RE: SUBMISSION ON IVANHOE ESTATE MASTERPLAN (SSD 17_8707)

This submission on the Ivanhoe Estate Masterplan (SSD 17-8707) has been prepared by Robinson Urban Planning Pty Ltd (**RUP**) for China Overseas Sydney Pty Ltd (**COLI**) being the owner of 137-143 Herring Road at Macquarie Park which occupies the corner of Herring Road and Epping Road to the immediate north-west of the Ivanhoe Estate.

Drawing No: DA01.MP.100[3]

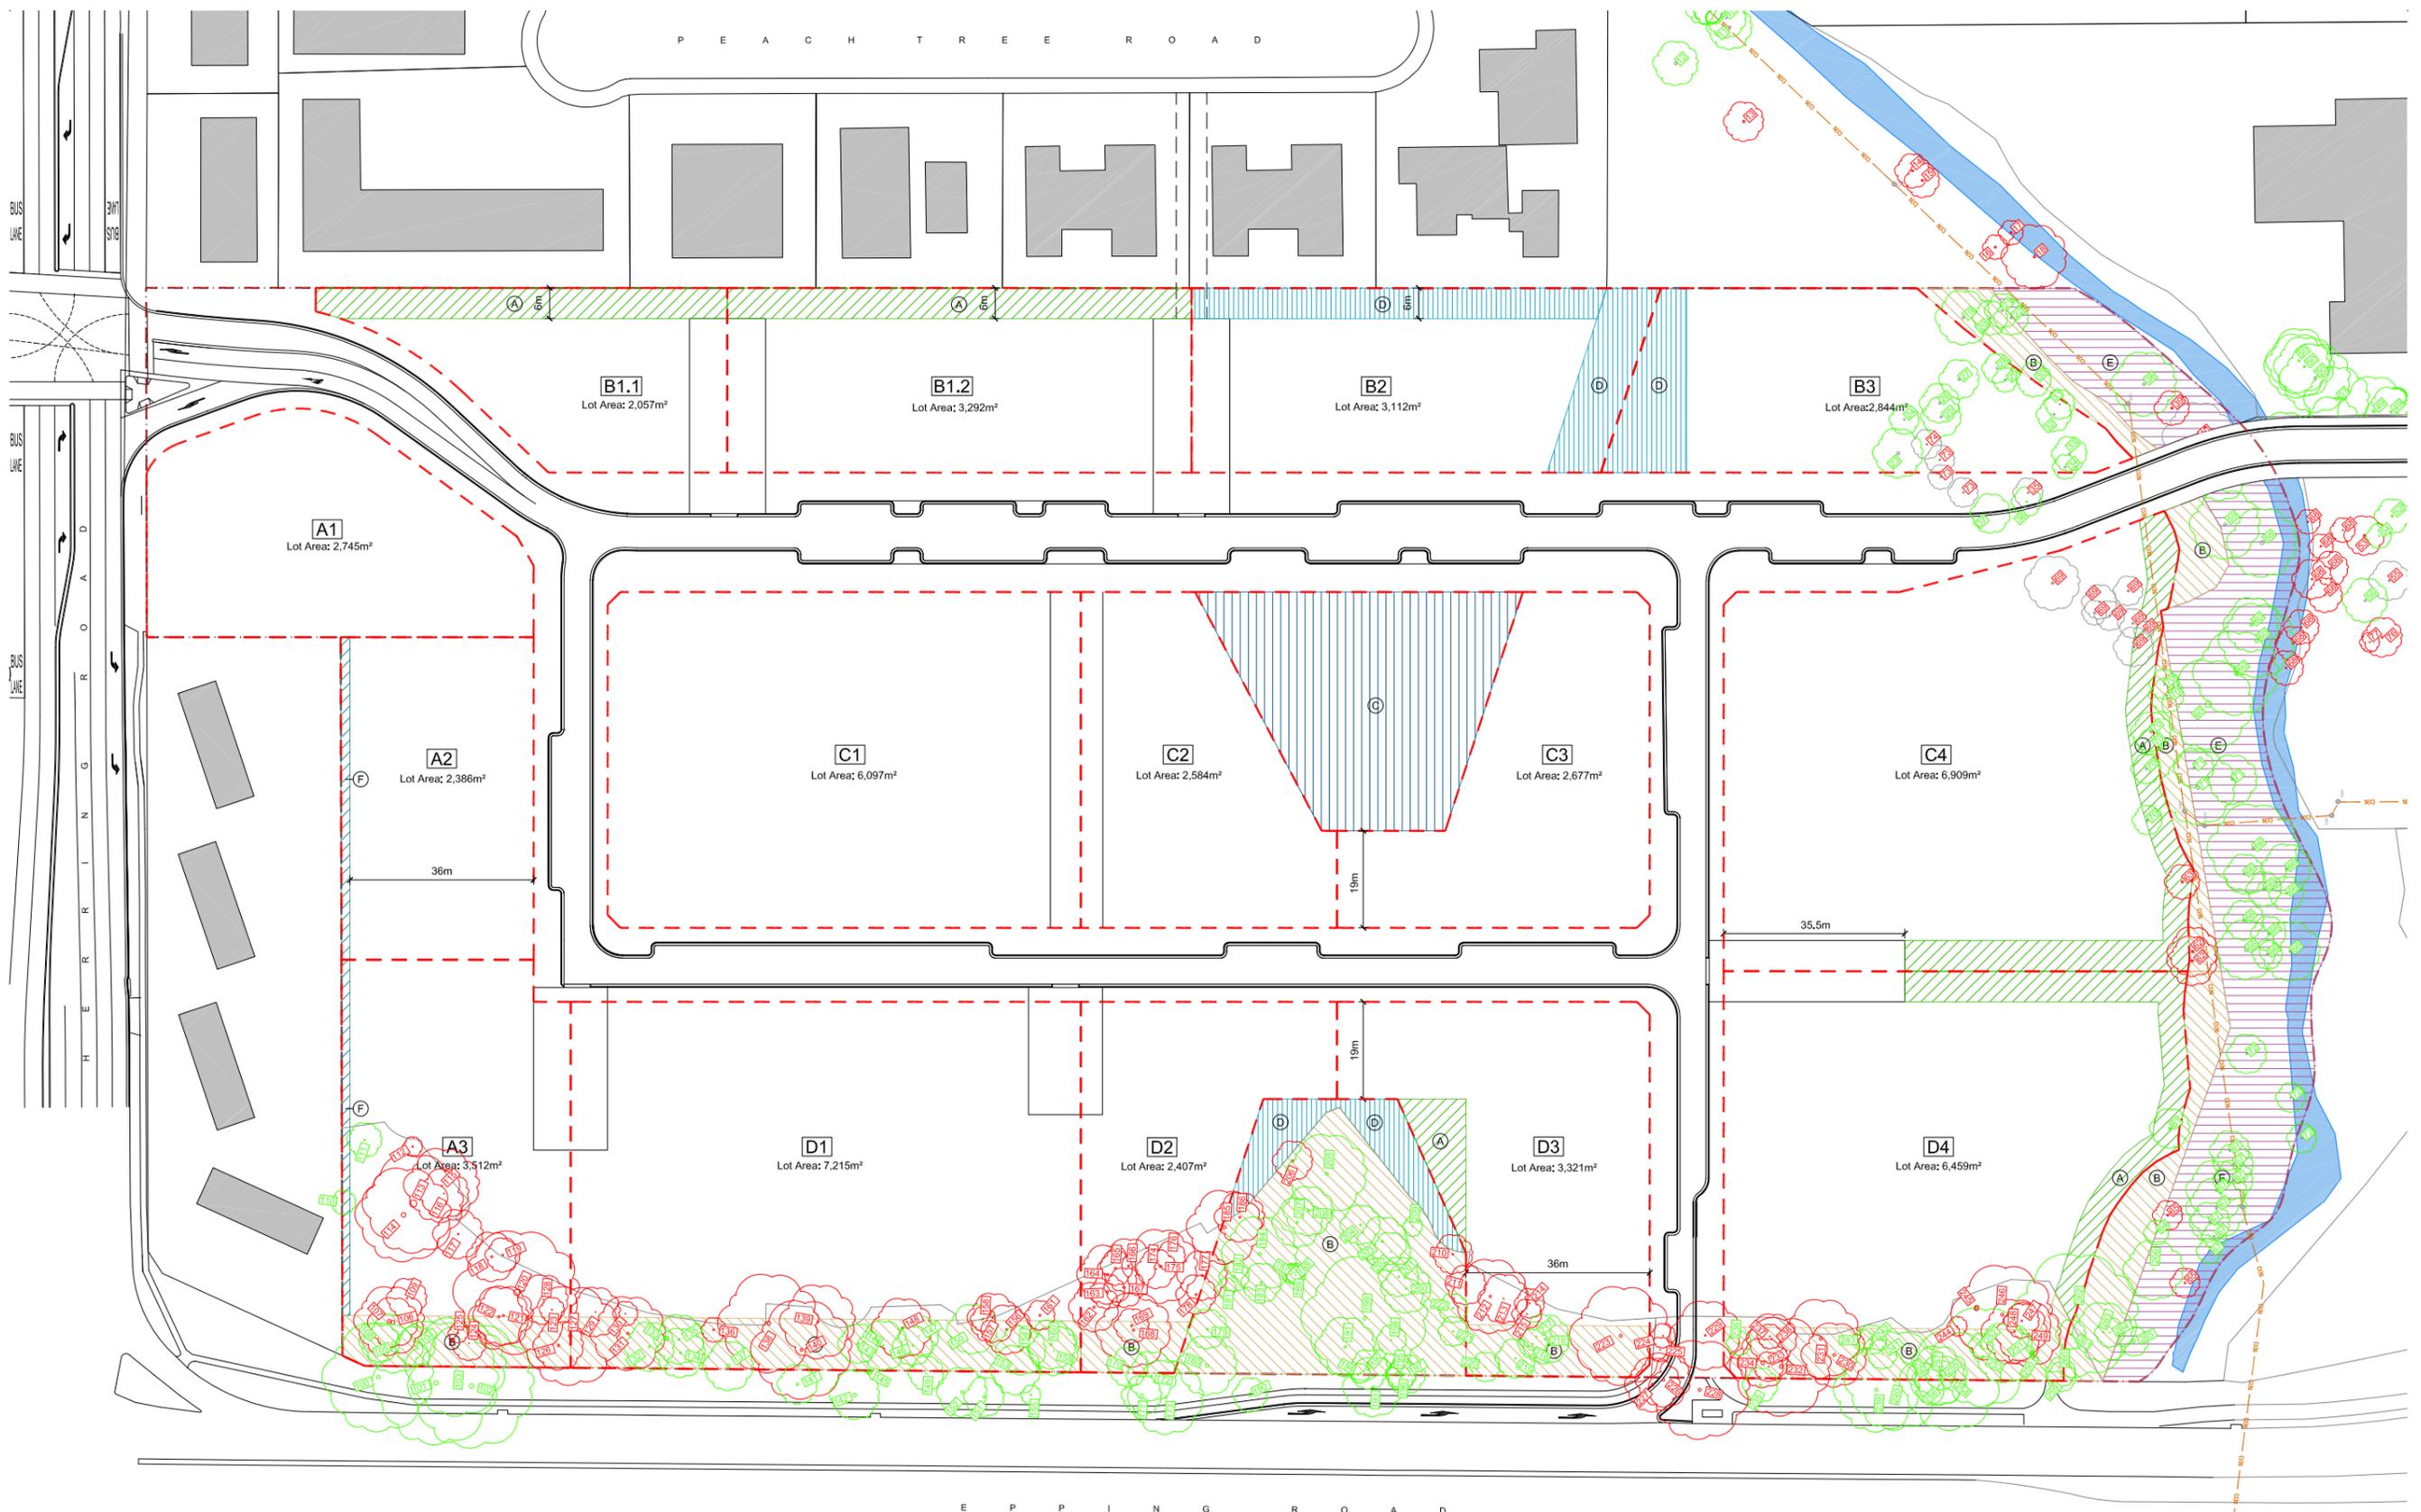
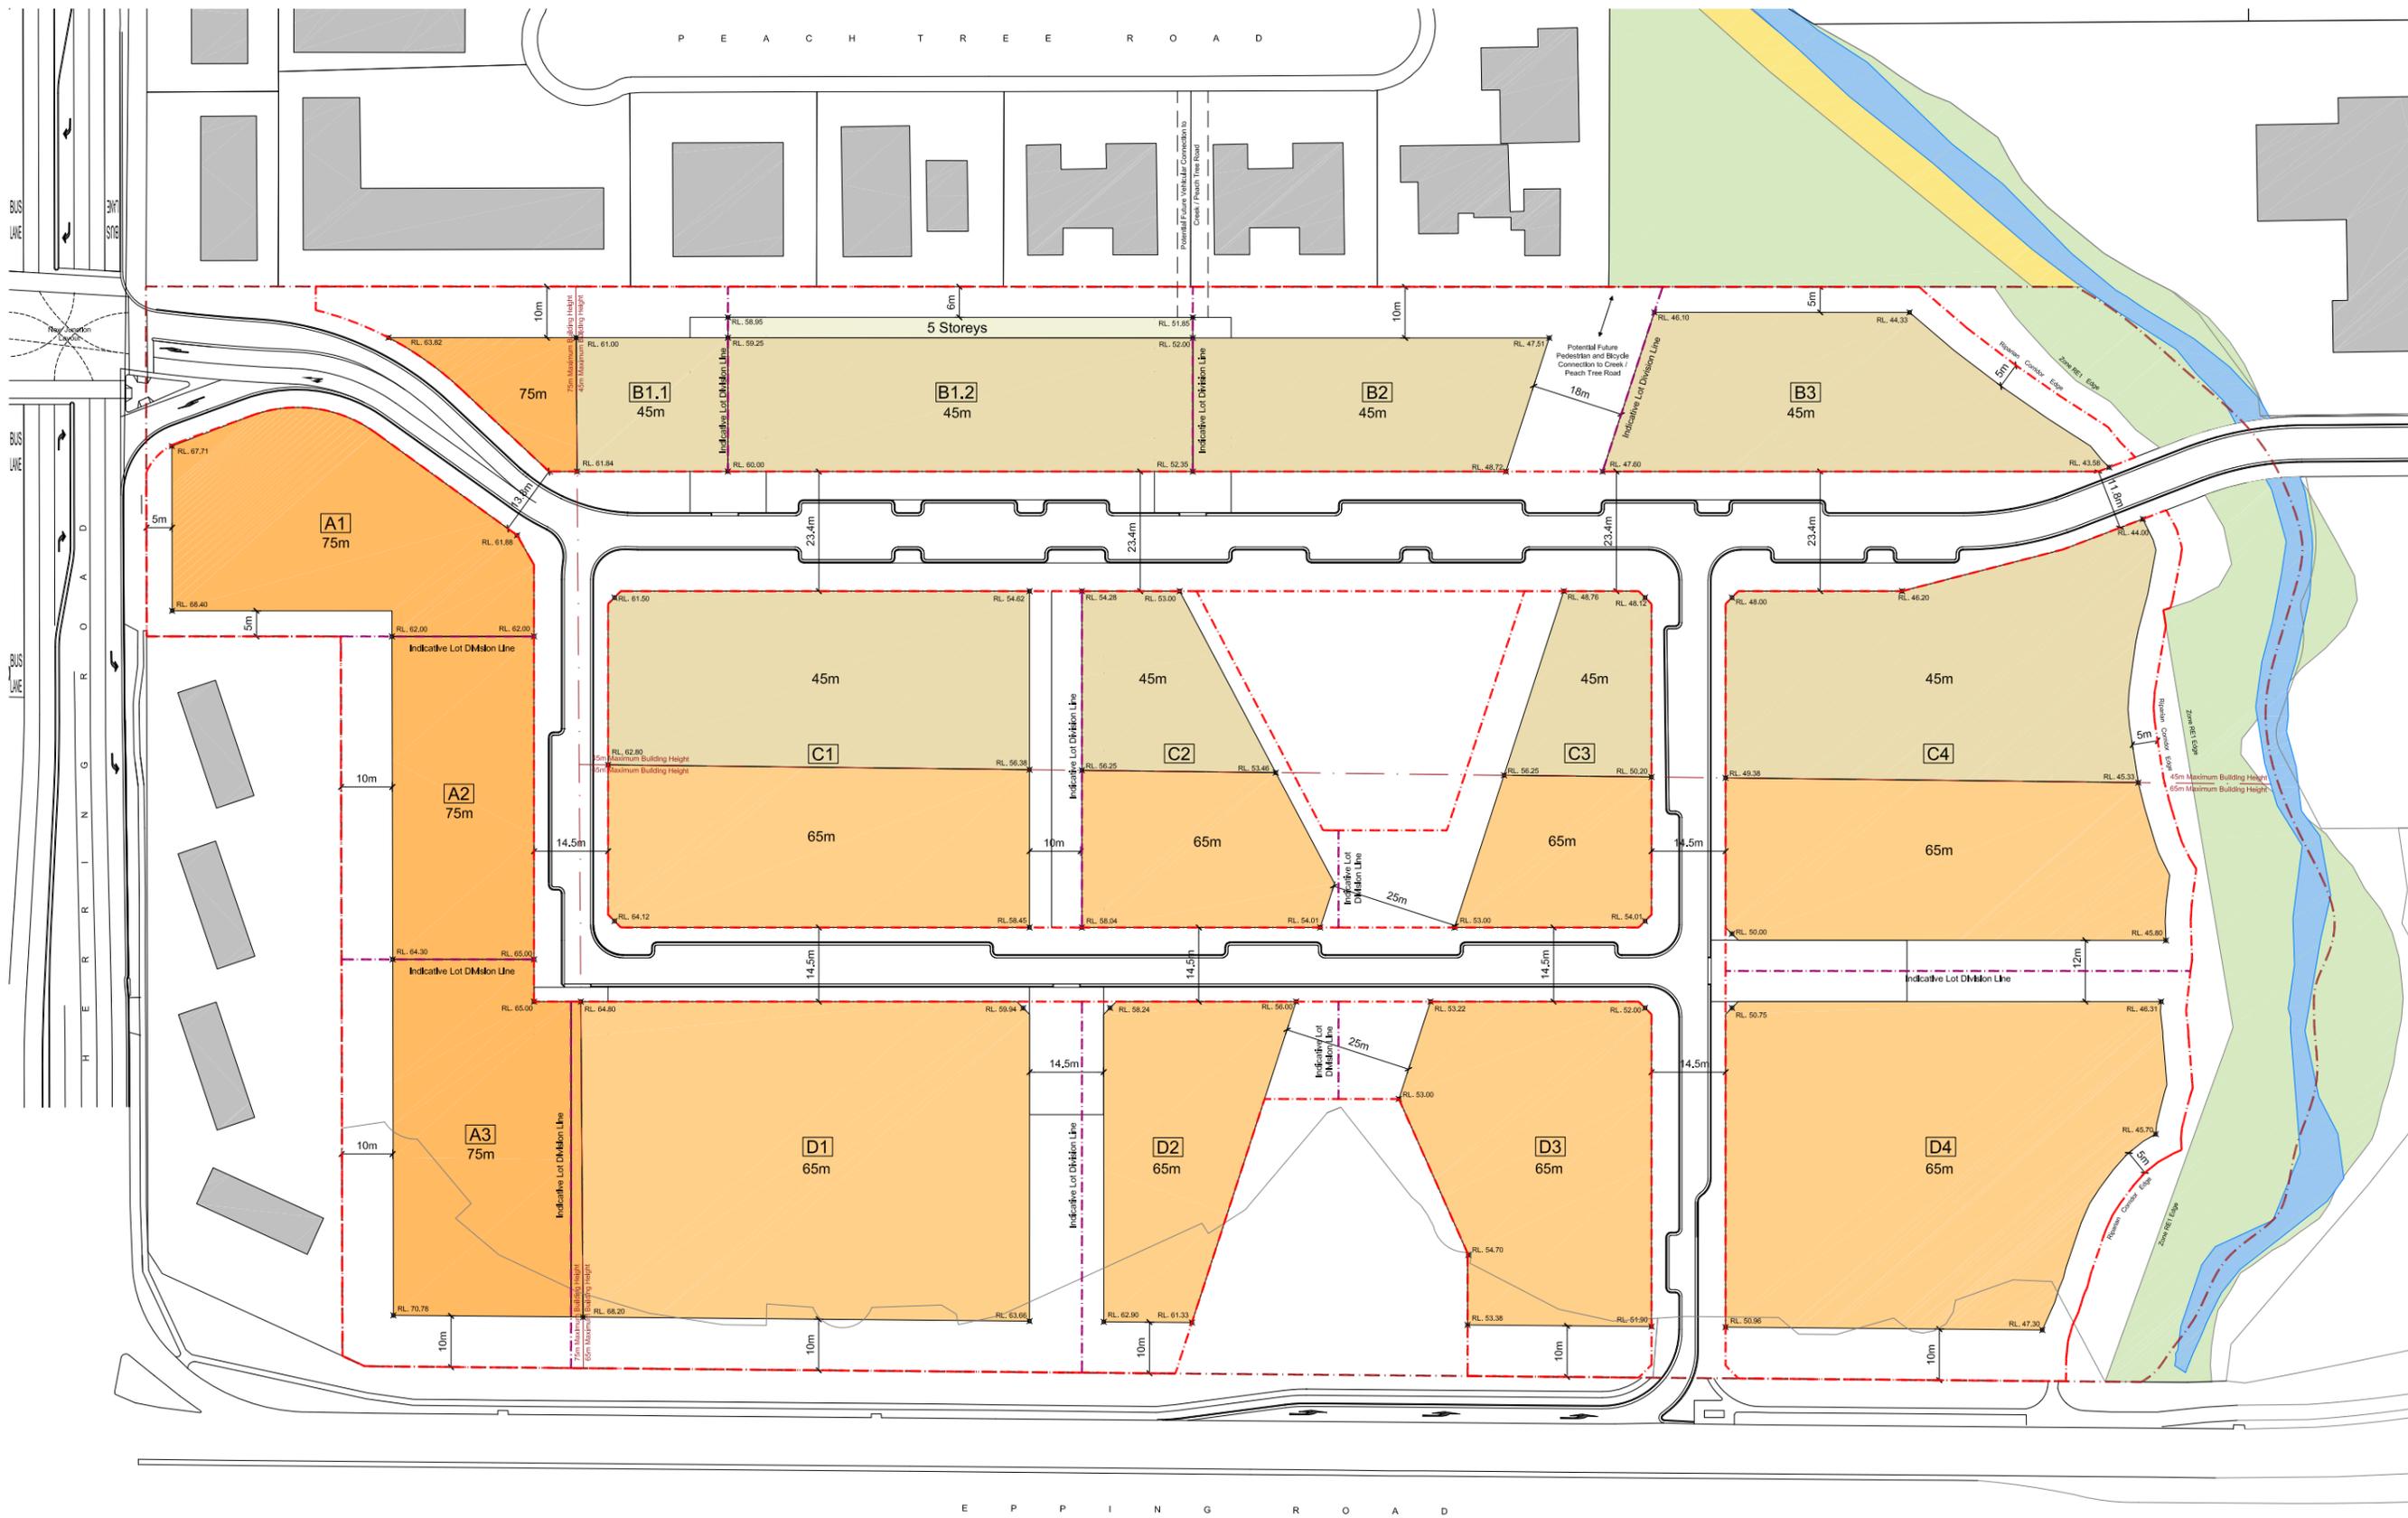
- Height
 - i. Master Envelope Control Plan (DA01.MP.100[3]) shows a consistent building height of 75m for Buildings A1, A2 and A3 (equal to 24 storeys), simply applying the Ryde Local Environmental Plan 2014 (**RLEP 2014**) height standard without responding to the site circumstances.

- iii. It is not reasonable for the applicant to seek the degree of height flexibility being sought in the Masterplan.
 - Building separation
 - i. Master Envelope Control Plan (DA01.MP.100[3]) no building separation between Buildings A1/A2 and A2/A3.

- Building articulation
 - i. Master Envelope Control Plan (DA01.MP.100[3]) shows no building articulation.
 - ii. In contrast, the Indicative Reference Scheme described in the Design Report illustrates and articulated and stepped buildings.

- iii. It is not reasonable for the applicant to seek the degree of building envelope flexibility being sought in the Master Plan.
 - Land use
 - i. Master Envelope Control Plan (DA01.MP.100[3]) does not show the distribution of land uses.

- a. Adjoining the COLI site, the Masterplan Envelope Control Plan (DA01.MP.100[3]) proposes:
 - 10m setback to the north-western (longer) side boundary, whereas the ADG requires a setback of up to 12m for the proposed 75m A2 and A3 building envelopes

- 5m setback to the western (shorter) side boundary, where the ADG would require a setback of up to 12m for the proposed 75m A1 building envelope.
- b. Adjoining existing apartments on Peach Tree Road, the Masterplan Envelope Control Plan (DA01.MP.100[3]) proposes:

- 10m setback whereas the ADG requires a setback of up to 12m for the proposed 45m/75m B1.1 and 45m B1.2 and B2 buildings
- c. The EIS does not provide any justification for these proposed ADG building separation non-compliances.

- e. The cl. 4.6 “Justification for Contravention of the Development Standard” consistently relies on the environmental effects of the Indicative Reference Design, which is provided for information only. A proper cl. 4.6 request must consider the impacts of the Master Envelope Control Plan (DA01.MP.100[3]) for which consent is sought.

Recommendation 1: The Masterplan Drawing Set and EIS should be amended and expanded to address the issues raised above. In particular, the Masterplan Drawing must be amended to more closely reflect the Indicative Reference Design. If this recommendation is not adopted, the EIS and Design Report must be amended to fully assess the environmental impacts of the Masterplan Envelope Control Plan.

Recommendation 3: The Masterplan Drawing Set should be amended to provide side boundary setbacks that comply with the ADG Objectives 2F and 3F.
